MEMORANDUM

PROJECT: SCEGGS
JOB NO.: 160441

SUBJECT SCEGGS DARINGHURST SSD-8993 – REQUEST FOR ADDITIONAL INFORMATION

The NSW Department of Planning requested additional information in relation to SCEGGS Darlinghurst Concept and Stage 1 (SSD-8993) in letter dated 19/12/19.

Project
SCEGGS DARLINGHURST MASTERPLAN
Drawing Title
WILKINSON HOUSE REDEV. ELEVATIONS
Drawing No.
AR.DA.3002

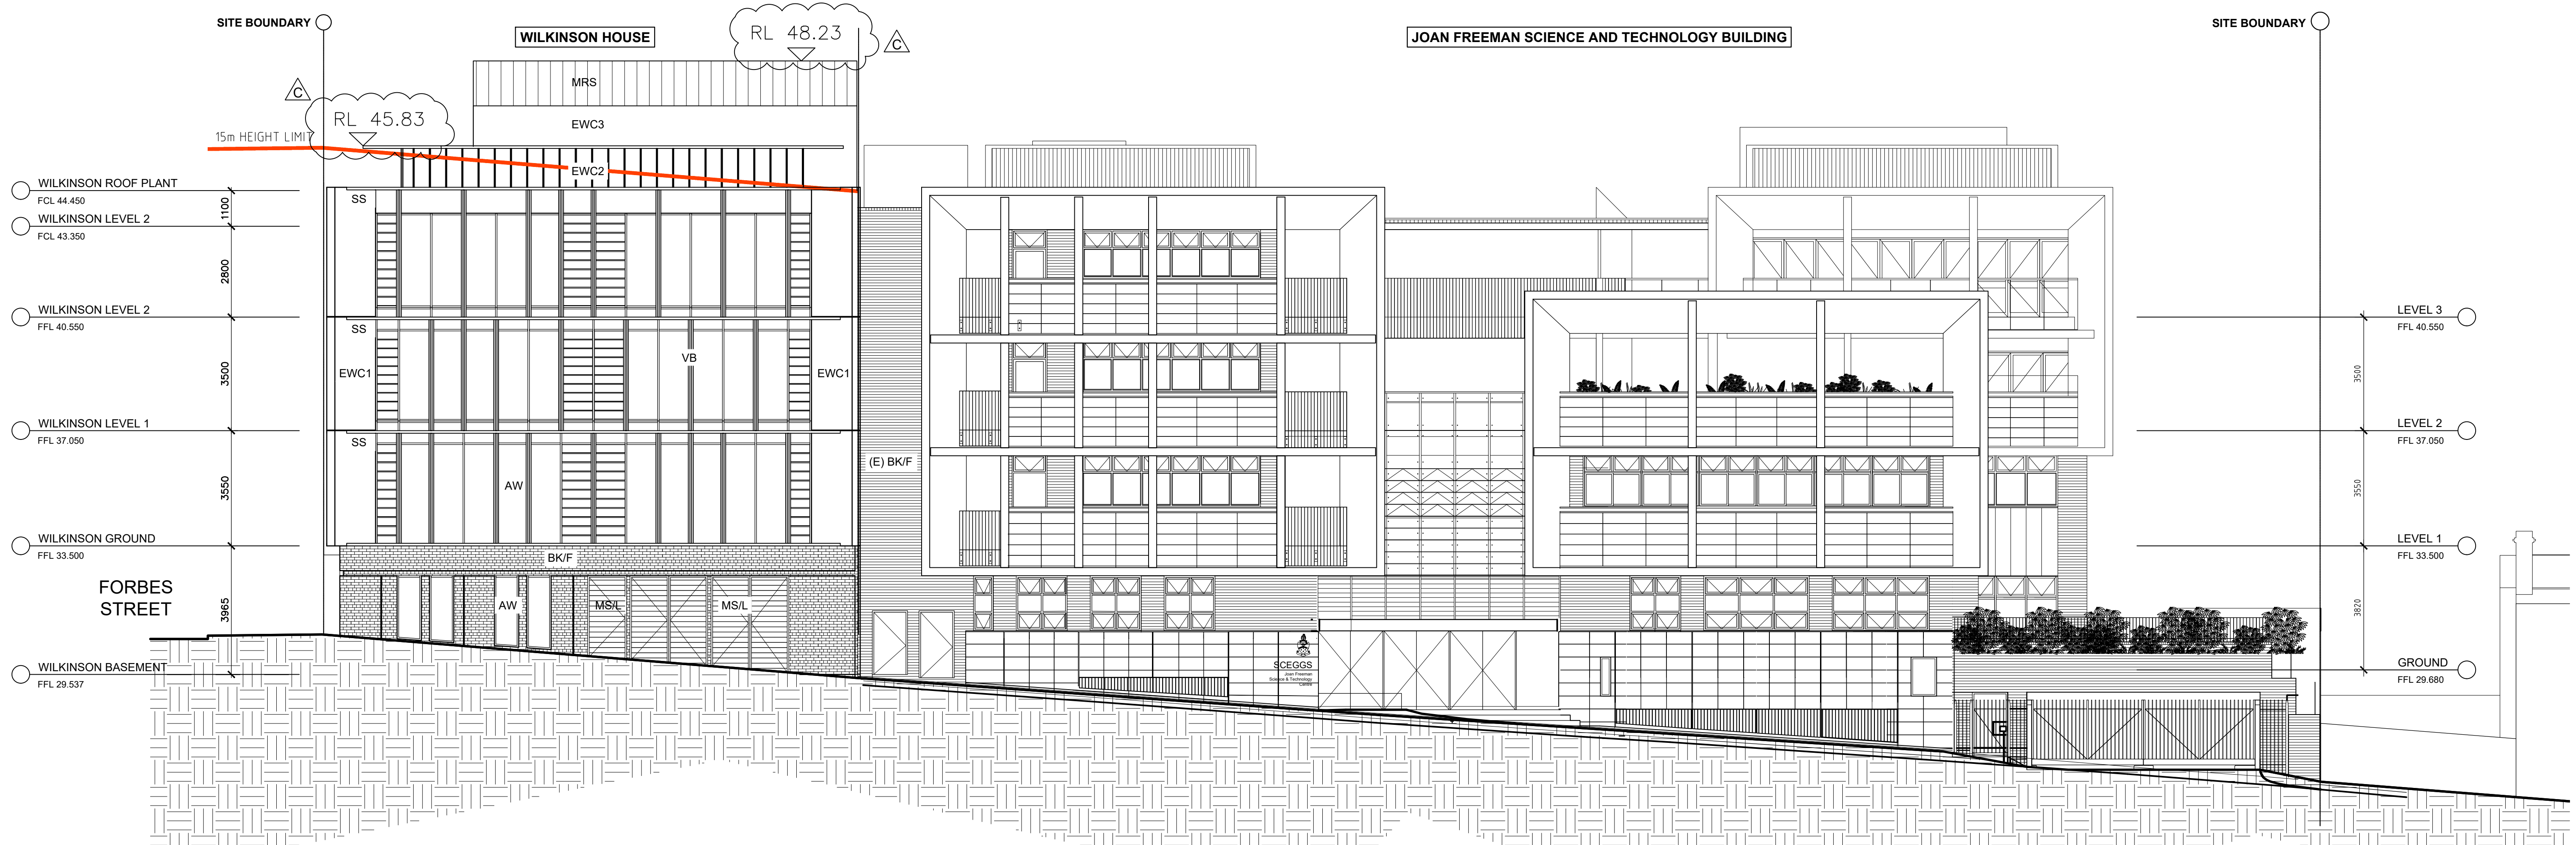
4. Confirm how the alcove created by the Wilkinson House recessed stair core on the Forbes Street frontage would be treated to prevent anti-social behaviour / litter and the like.

14. The Department notes that the architectural drawings (Concept and Stage 1) do not include the maximum RLs for Wilkinson House (drawings AR.MP.3002c, AR.DA.2105b, AR.DA.3002b). Provide updated architectural drawings annotated with the maximum RL heights (roof plan and elevation) for Wilkinson House, including highest point of plant enclosure(s).	<p>The Architectural Drawings have been annotated with the maximum RL heights.</p> <p>The following Architectural Drawings have been updated:</p> <ul style="list-style-type: none"> - AR.MP.3002, Rev D - AR.DA.2105, Rev C - AR.DA.3002, Rev C
<p>16. For reference:</p> <p>a) update (to include RtS changes) and provide a copy of the 'landscaping/tree' image that was located at page 13 of the EIS Architectural Design Report.</p> <p>b) provide an 'as proposed' car parking/access image, based on the image that was located at page 15 of the EIS Architectural Design Report.</p> <p>c) provide a photograph of the Old Gym Building.</p>	<p>Architectural plan diagrams from page 13 and 15 of the EIS Architectural Design Report have been updated as requested to show the RtS proposal.</p> <p>Updated diagrams are attached.</p> <p>A photograph of the existing Old Gym Building is provided below.</p>

- 1) create a visual separation between the building and the adjacent Centenary Sports Hall and modulate the high-quality facade.
- 2) allow for the fire egress door to be discreetly located on the side wall of the alcove, which avoids having a blank fire door facing the street and allows for the egress door to not open out over the property boundary (which it is not permitted to do).

The external alcove created by the Wilkinson House recessed stair core is fully visible from within the building by a fully glazed facade, providing natural surveillance and security of this area. The alcove will also be fully lit at night time so that there are no dark or shaded areas to hide in.
